Application for Removal or Variation of a Condition following Grant of Planning Permission or
Listed Building Consent

Removal of conservatory and new single storey extension.

22/01902/HOUSE

Condition 2: The development hereby permitted shall be carried out in accordance with the approved plans

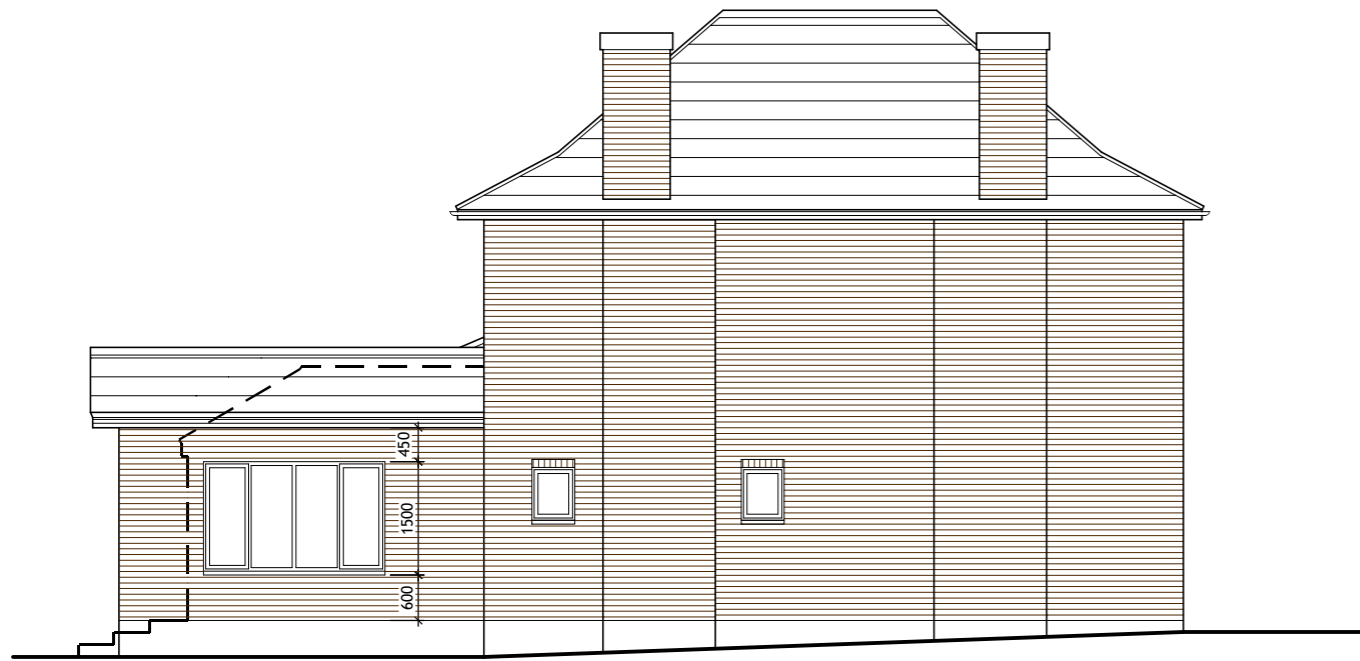
Existing eaves height to single storey rear extension was higher than shown on existing elevations

The proposed extension has be revised to ensure the gutter lines though with the existing
